To: All Staff
From: Environmental Health
Date: January 27, 2026
Subject: SX-26-00002 Rogers

ROGERS GARAGE
221 WOODSCREEK LANE
ELLENSBURG, WA 98926

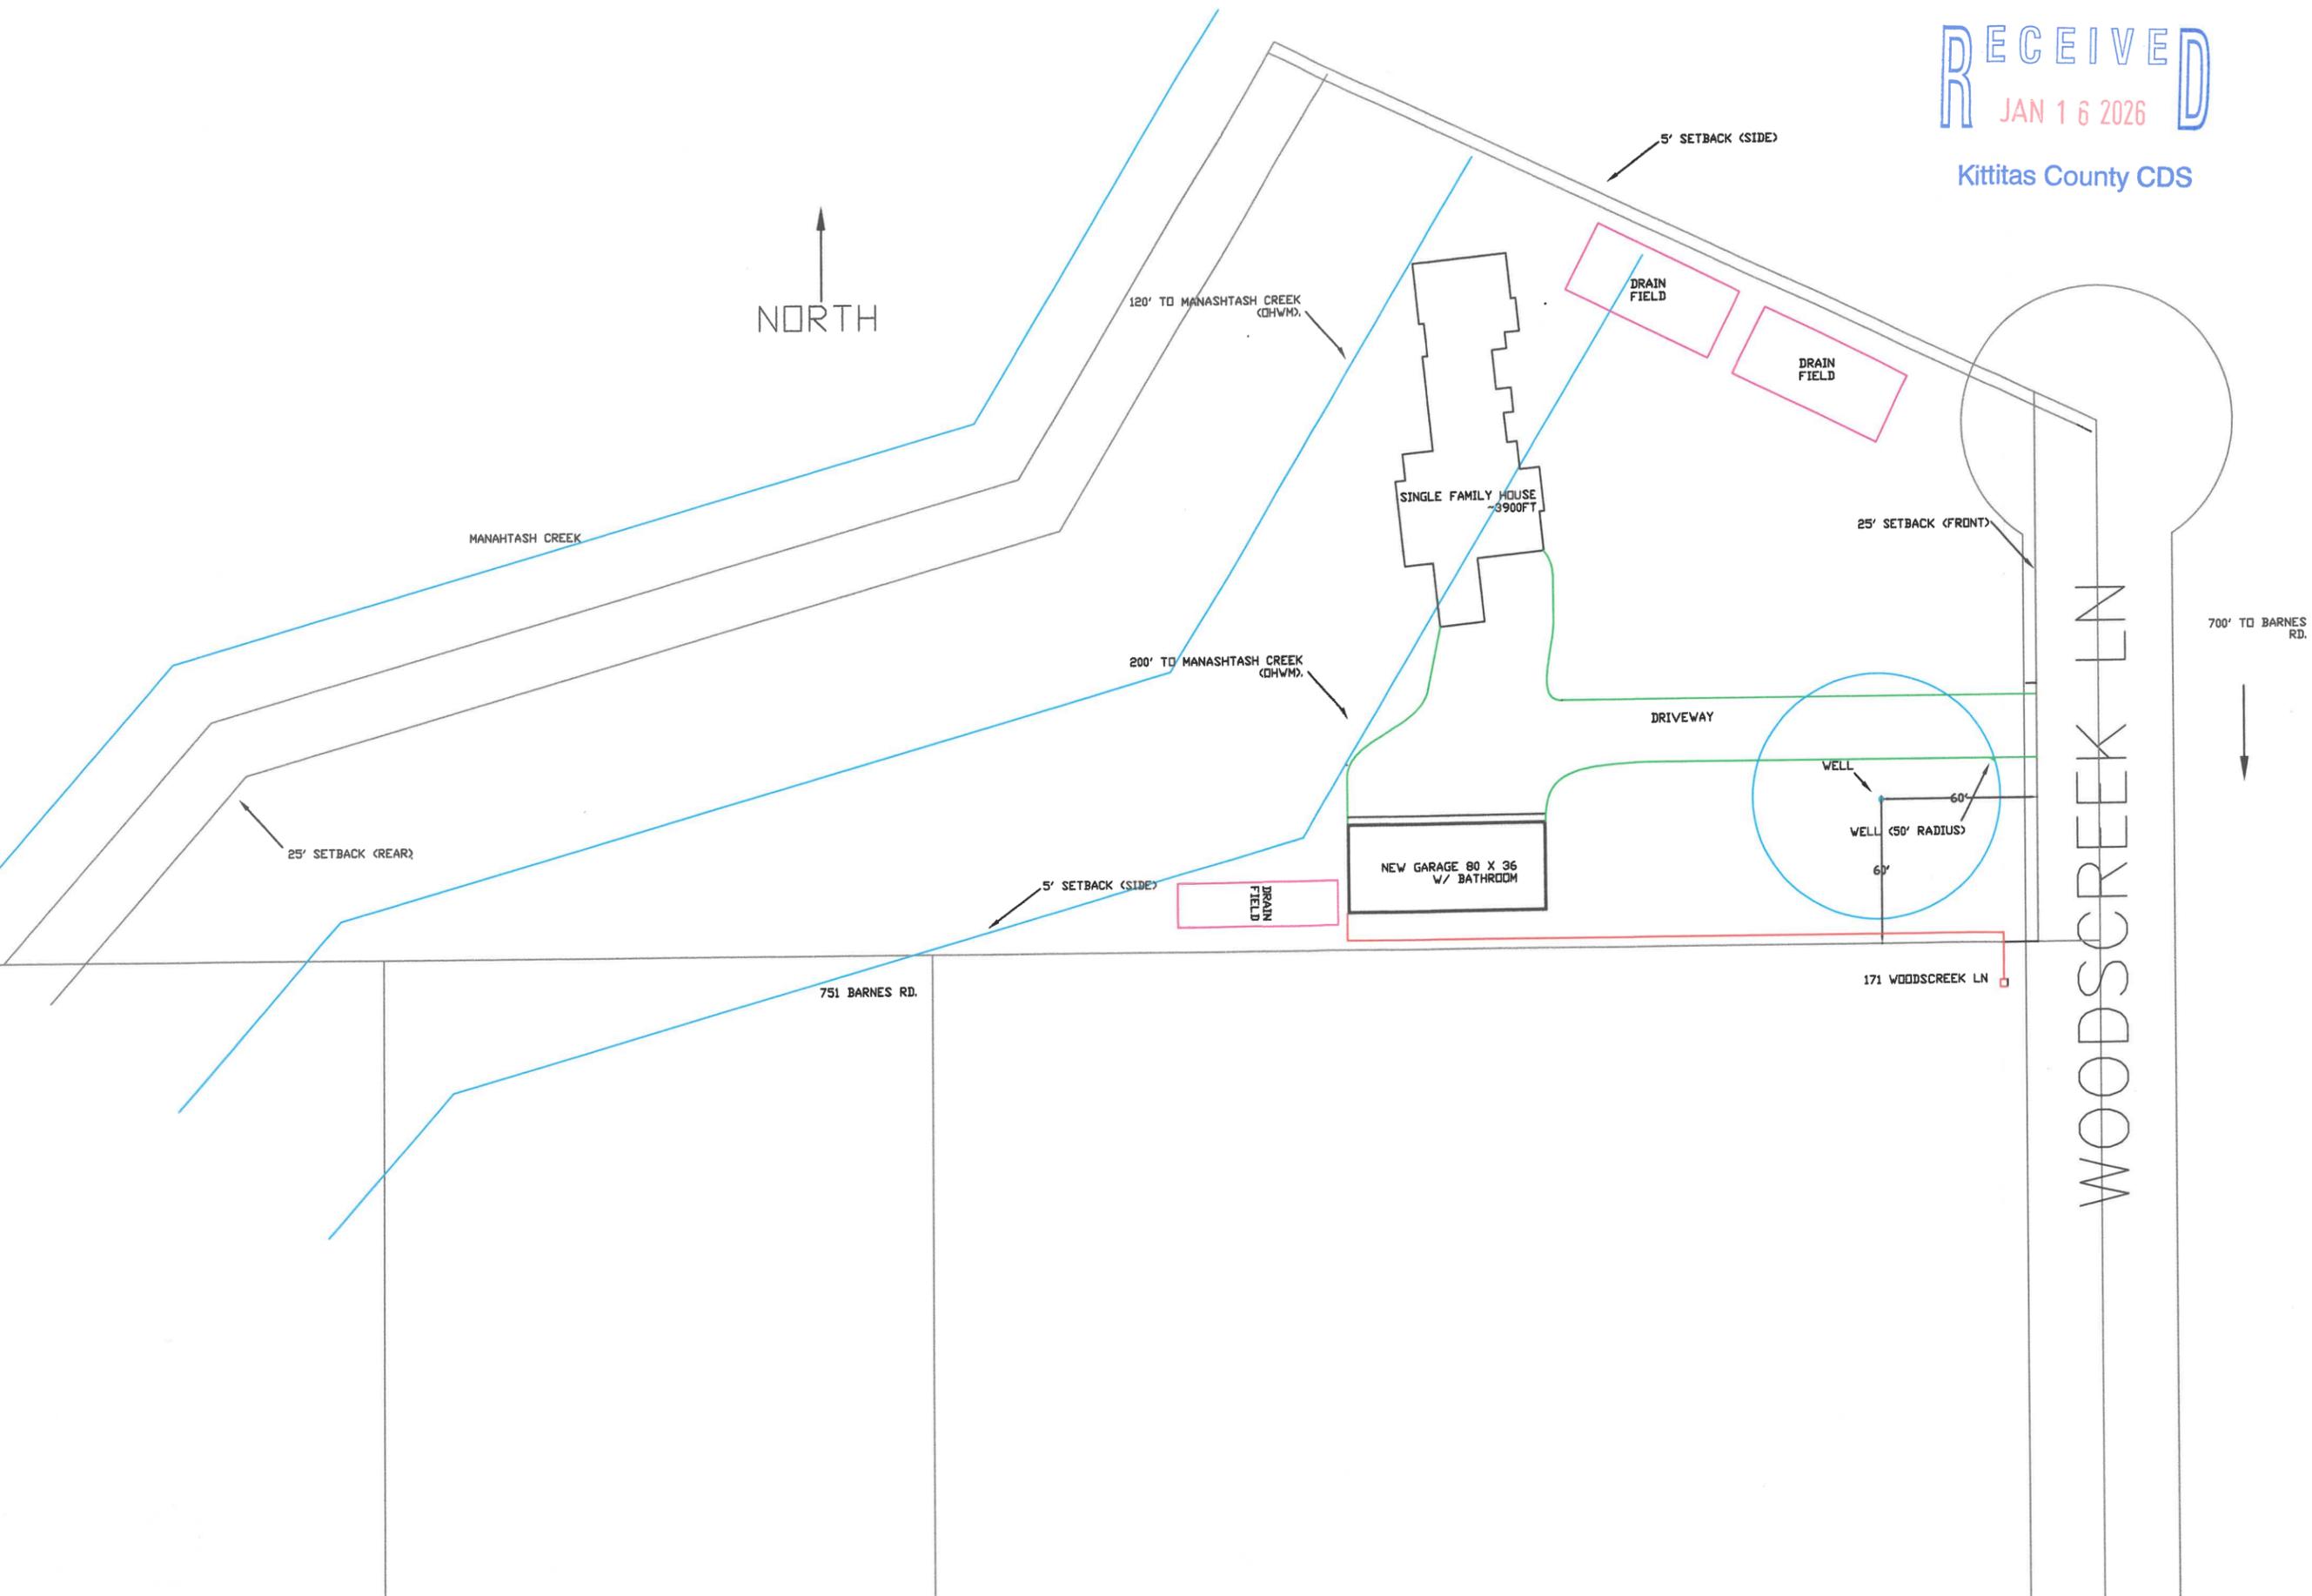
Drinking Water	<ul style="list-style-type: none">• No comment. Well is already drilled and in place.
Wastewater	<ul style="list-style-type: none">• No Comment for shop drain filed, drain filed is finalized and meets setbacks.• For residence, maintain 100ft setback from surface water.
